**Cherwell**  
DISTRICT COUNCIL  
NORTH OXFORDSHIRE

# NOTICE OF DECISION

**Proposal:** Discharge of Conditions 12 (Construction Management Plan), 13 (Landscape Environment Management Plan), 14 (Construction Environment Management Plan), 21 (Woodland Management Plan) and 31 (Habitat Management Plan) of 22/01144/F

**Location:** OS Parcel 5700 South West of Grange Farm, Street Through Little Chesterton, Chesterton

drawing title	Detailed Landscape Proposals	Sheet 1 of 17
date	18 OCTOBER 2022	drawn by LCH
drawing number	edp2425_00171	checked BC
scale	1:1500 @ A0	QA RB

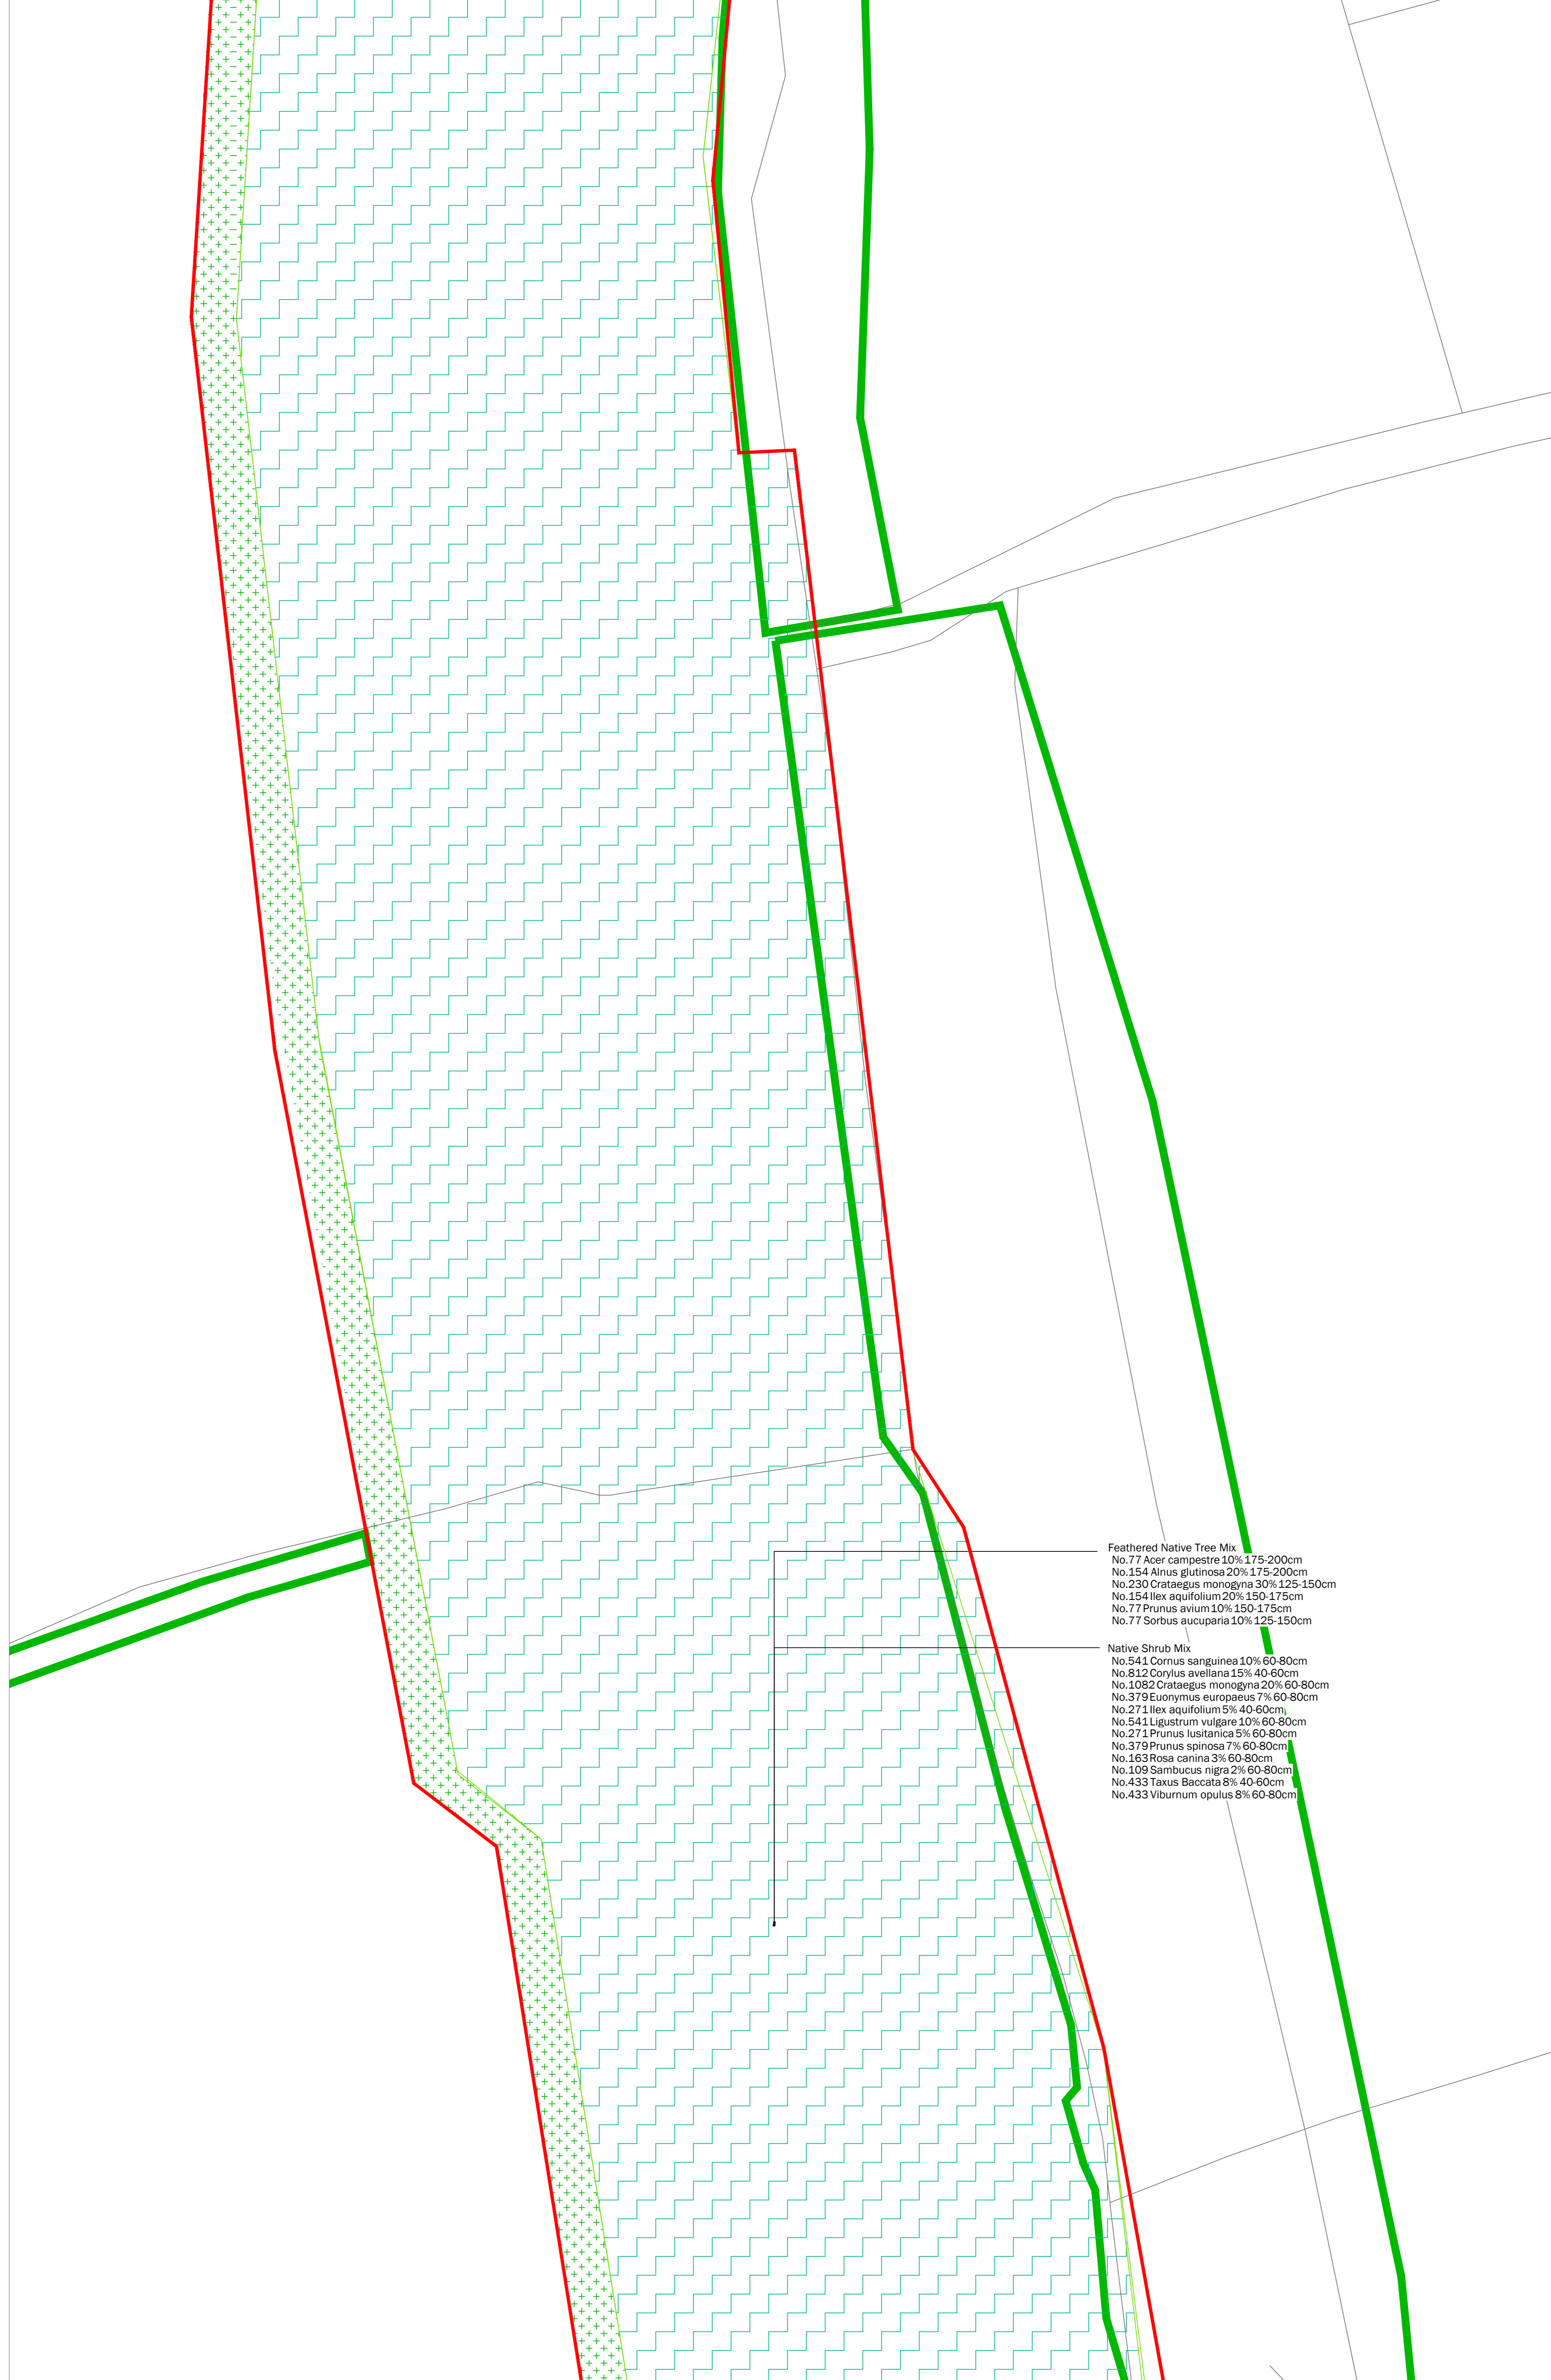
- Medallion turf is not suitable for an ecological buffer zone as it contains aggressive grass species which would dominate native plants and prevent their establishment. The ecological buffer zone should only be planted with native species and include some trees and shrubs to provide habitat, refuge, food and some shade along the corridor. *Quercus Ilex* is naturalised in the UK but not native to the UK. Native species are preferred due to their increased benefits for wildlife.
